From: Jean Fraser
To: Tarling, Jeff
Date: 8/22/2014 10:17 AM
Subject: 2282 Congress - amendment to approved site plan
Attachments: C-2.0 Amended Site Layout Plan.pdf; C-5.0 Landscape Plan.pdf; C-8.0 Landscape Details.pdf

Can you please take a look at these- they have added planting on the east side and reduced the impervious surface. Need a "sign off" please.

i. That the applicant shall submit a revised Landscaping Plan (with notes), for review and approval by the Planning Authority and City Arborist prior to the issuance of a building permit, that meets the recommendations set out in Jeff Tarling's e-mail dated 5.10.2013; and

SHEET TITLE
LANDSCAPE PLAN

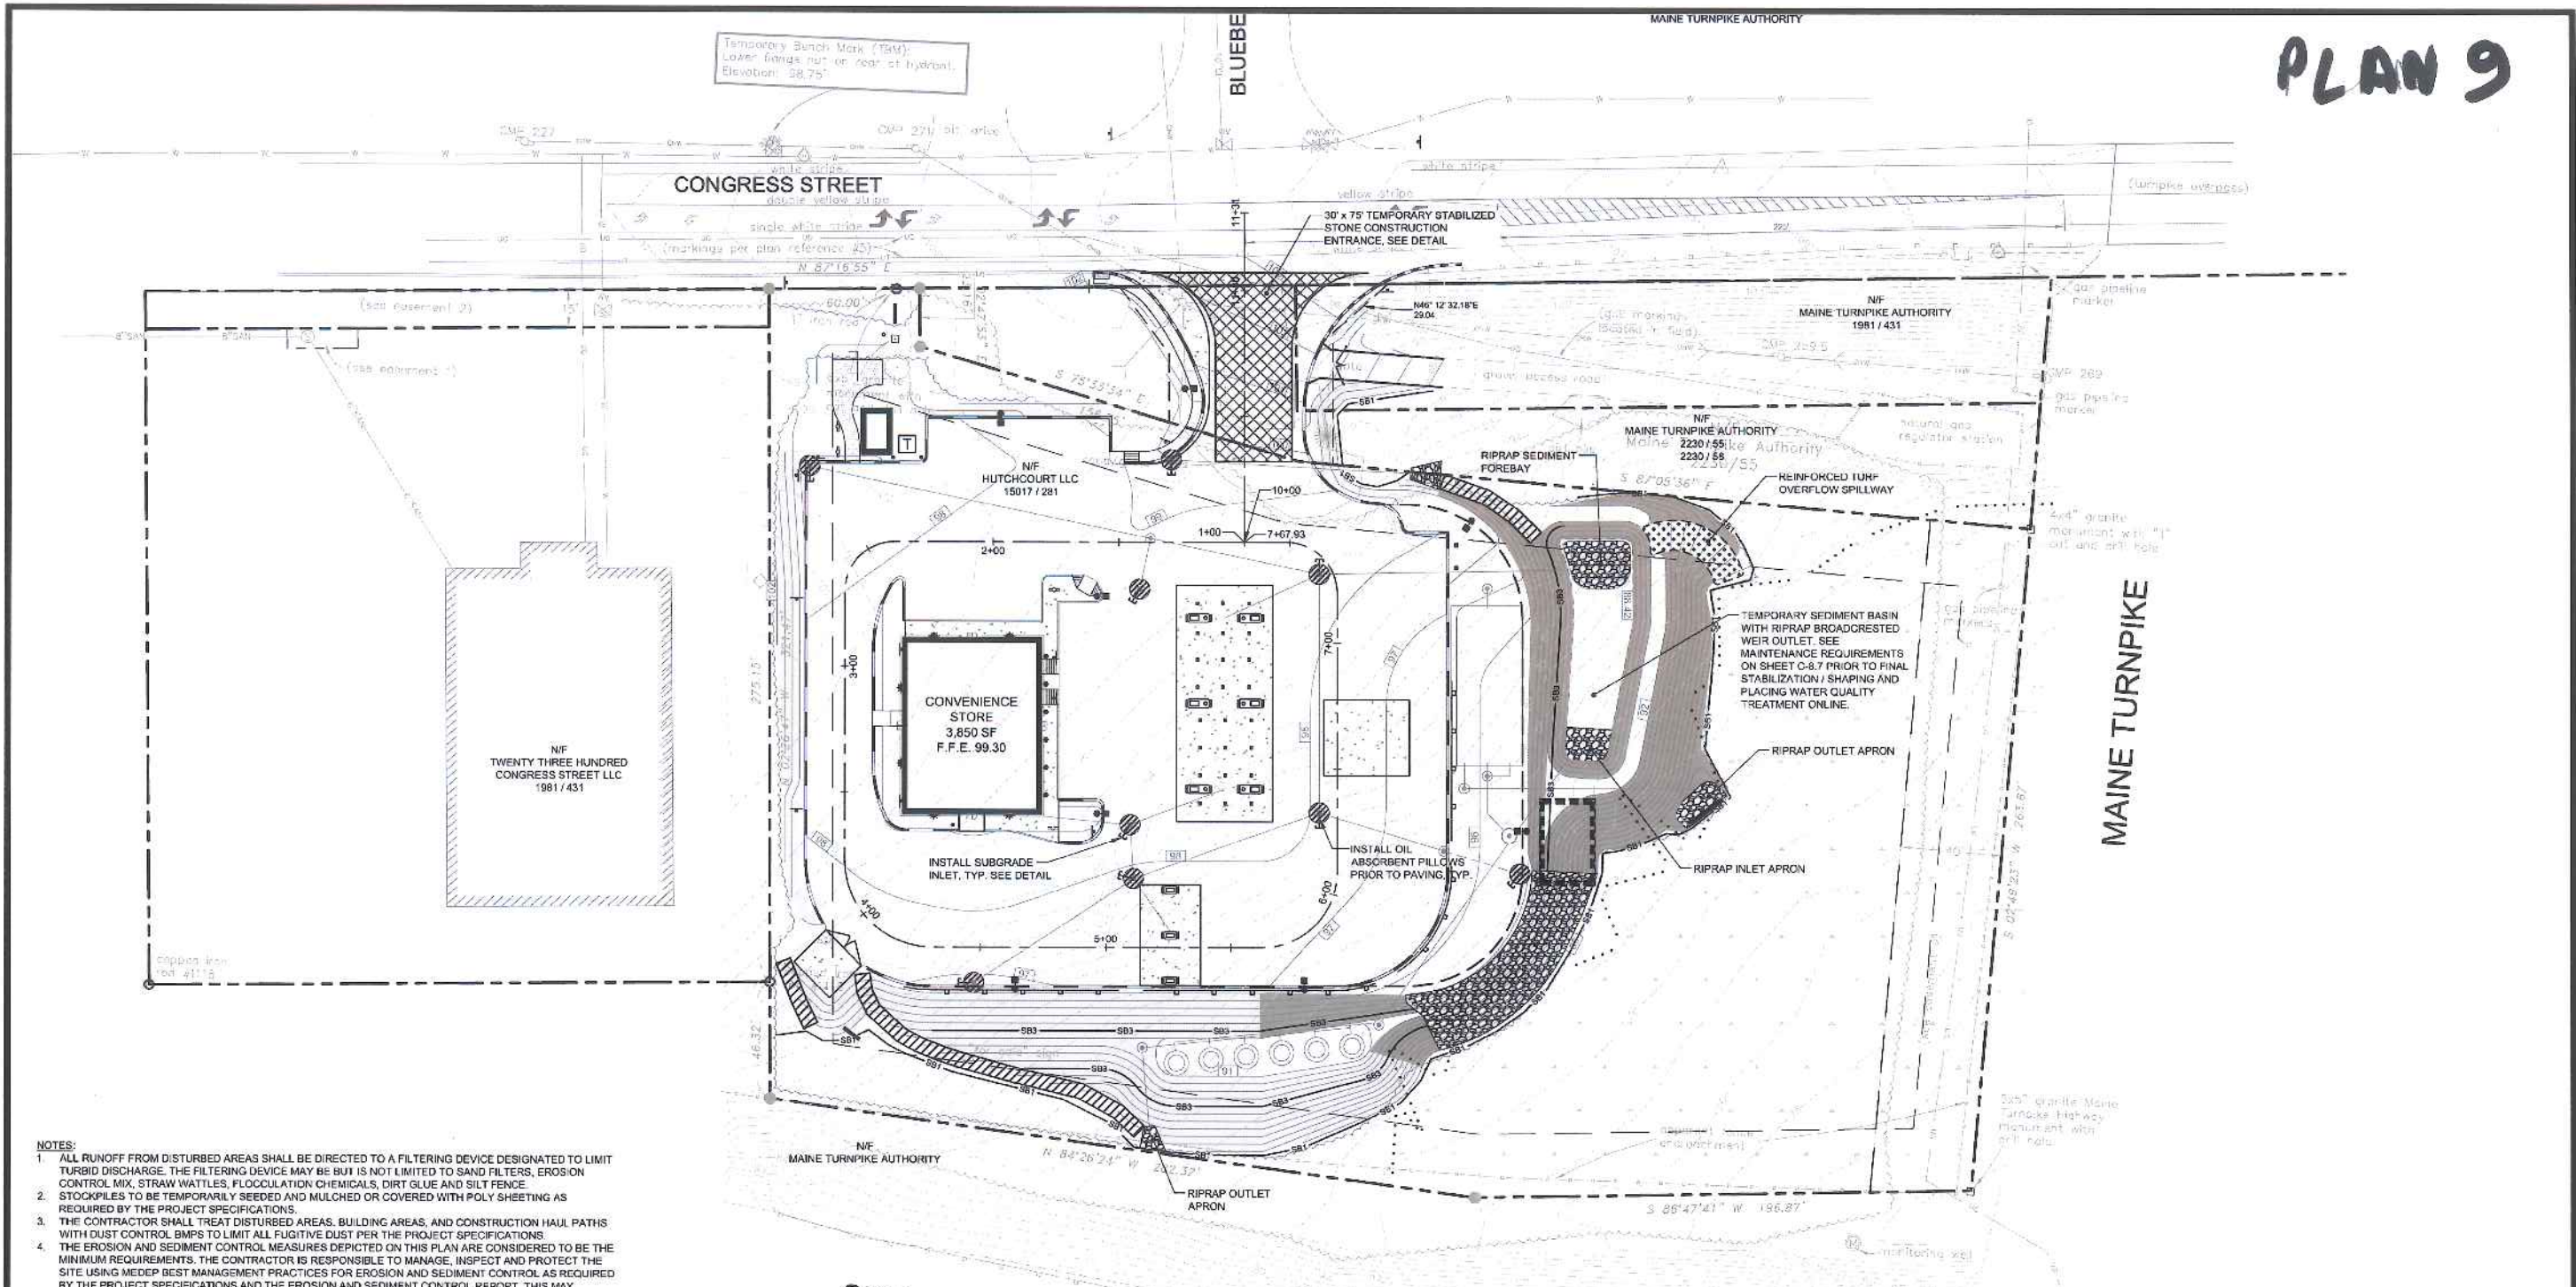
Your 5.10.13 comment was: b) Trees in parking lot - In the area shown as snow storage, and addition one to two trees could be set back away from the edge of pavement to still allow snow clearing and meet the parking lot tree / shrub standards.
